Application Ref: H09-0760-26

Proposal: **Change of use of agricultural land to Gypsy / Traveller site comprising 4 no. mobile homes and 2 no. touring caravans - Retrospective**

Location: **Land behind Middle Earth, Main Road, Holbeach Drove, Spalding PE12 0PS**

Deferral: LCC is not currently in a position to support the application and requests further assessment, supporting evidence, revisions and/or dialogue, as set out in the response.

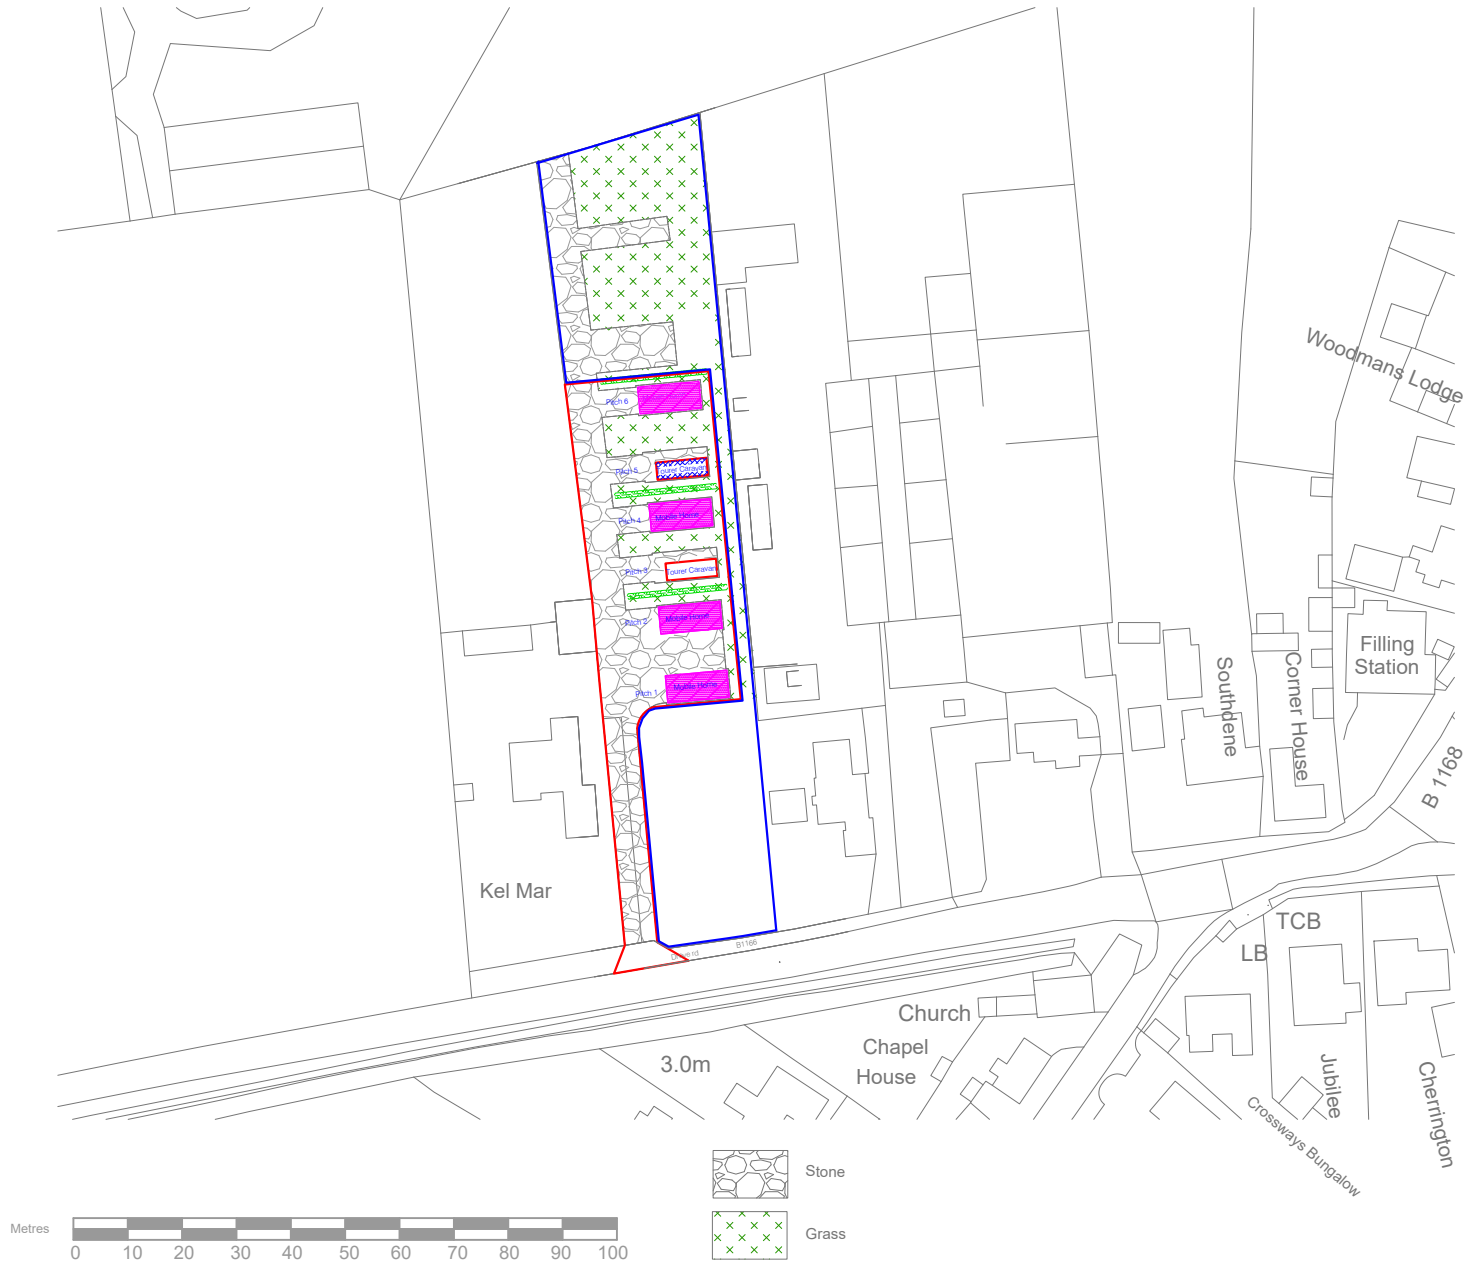
The Local Highway Authority notes that the development is retrospective and is served by an existing vehicular access from Drove Road. The existing access would require upgrading, together with provision of an appropriate pedestrian connection to the existing footway network.

The information currently available indicates that the access and footway works may affect land forming part of the separately approved residential development, one plot of which is understood to have commenced. It is therefore unclear whether the necessary highway works can be delivered without conflict with the approved residential layout.

Please provide an access plan demonstrating that the access and footway are physically deliverable and that the works would not prejudice the safe access, parking or turning arrangements associated with the approved residential development.
